DESCRIPTION OF REQUEST: FINAL SIGN-OFF OF AN EPC APPROVED SITE PLAN FOR BUILDING PERMIT

OFFICIAL NOTIFICATION OF DECISION

October 14, 2016

**Project# 1002717
16EPC-40045 Site Development Plan for Building Permit**

CONSTRUCTION DEPARTMENT
2727 NORTH CENTRAL AVENUE
PHOENIX, ARIZONA 85004
P: (602) 263-6502

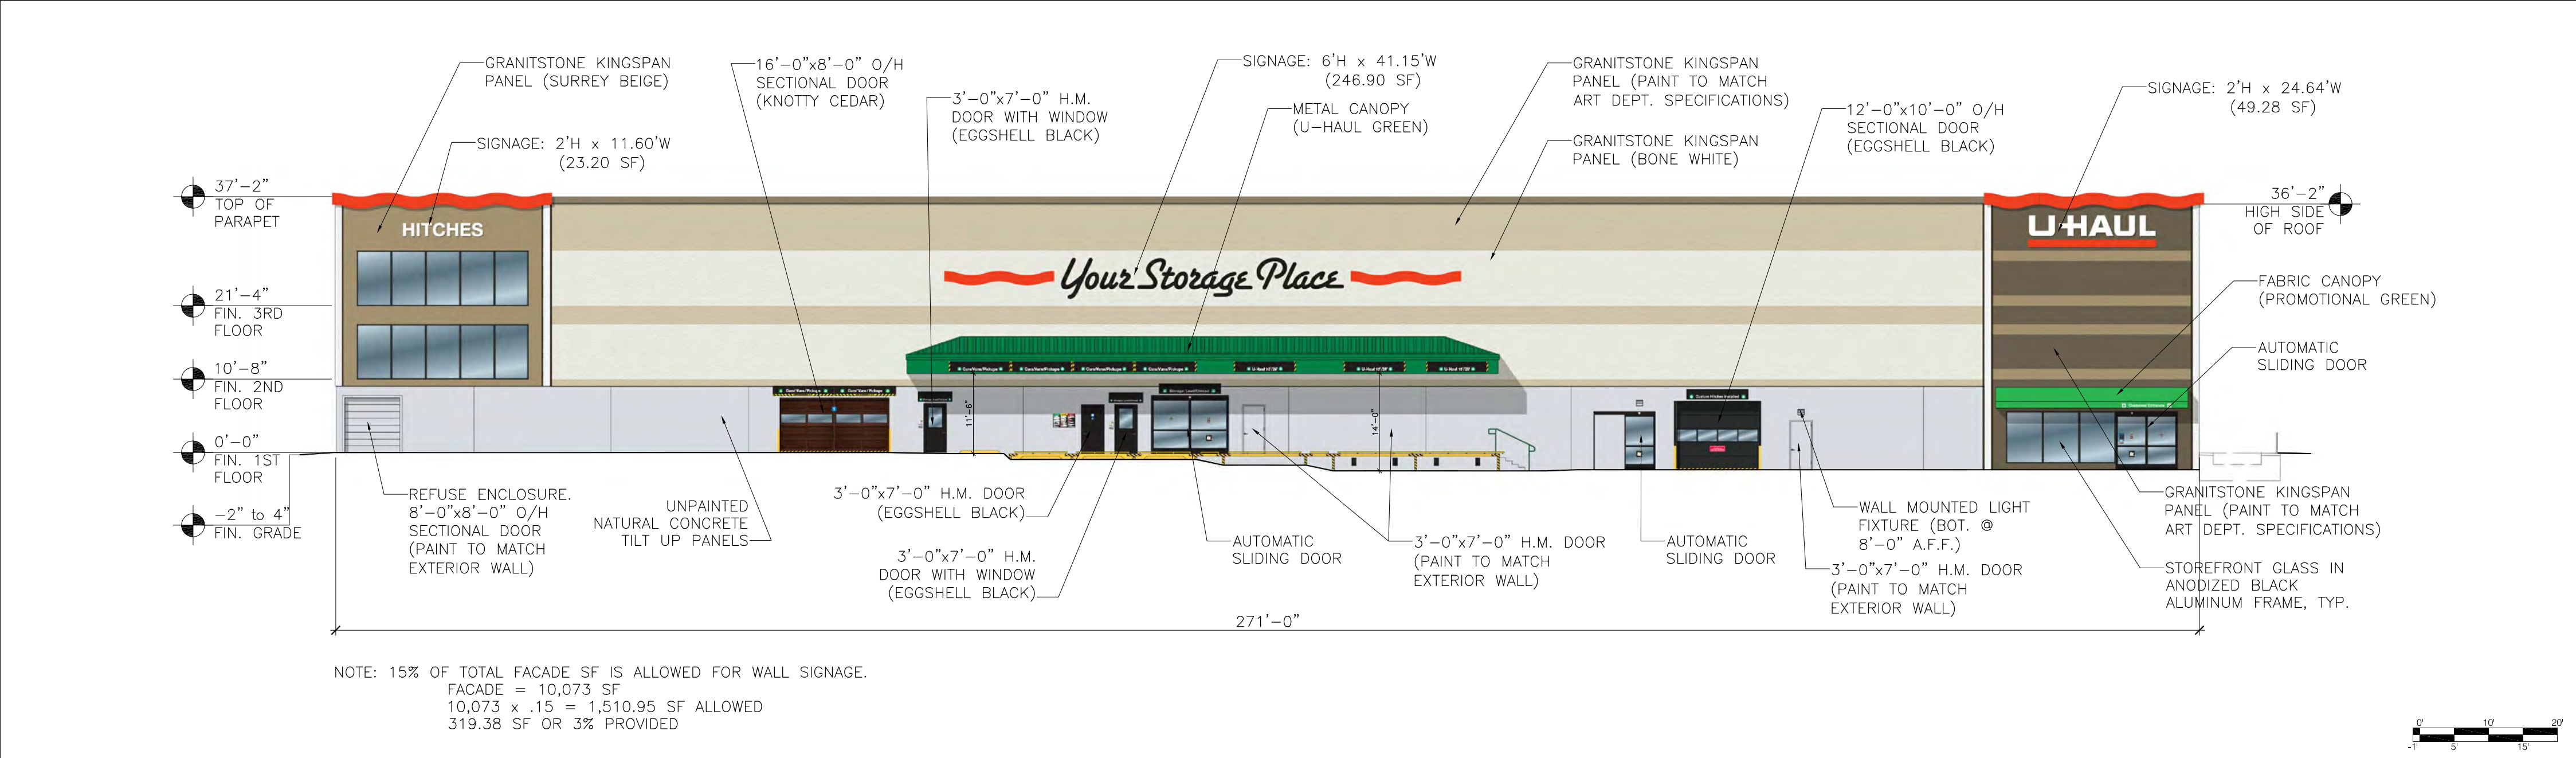
6. The applicant shall add a stucco finish to all proposed MCBI metal wall panels along each of the building elevations shown on Sheets A2 and A3, in order to better integrate the development with the surrounding development and address neighborhood resident comments as outlined in the facilitated meeting report (see attached).

9. The applicant shall amend the building mounted signage diagrams on Sheet A2 to meet the requirements of the C-2 zone Section 14-16-2-17(A)(10)(d)(2) which states that building mounted signage height shall not exceed 30 feet, or seek a signage variance through the Zoning Hearing Examiner (ZHE) concurrent with submitting an application to DRB for final sign-off.

10. The applicant shall amend the notation section under each building façade diagram on Sheet A2 to correspond to the appropriate building mounted signage square footage listed under Section 14-16-2-17(A)(c)(2)(i – iii) as noted below:

- a. Northern façade: Maximum allowed = 10%
 - b. Southern façade: Maximum allowed = 15%
 - c. Eastern façade: Maximum allowed = 10%
 - d. Western façade: Maximum allowed = 15%
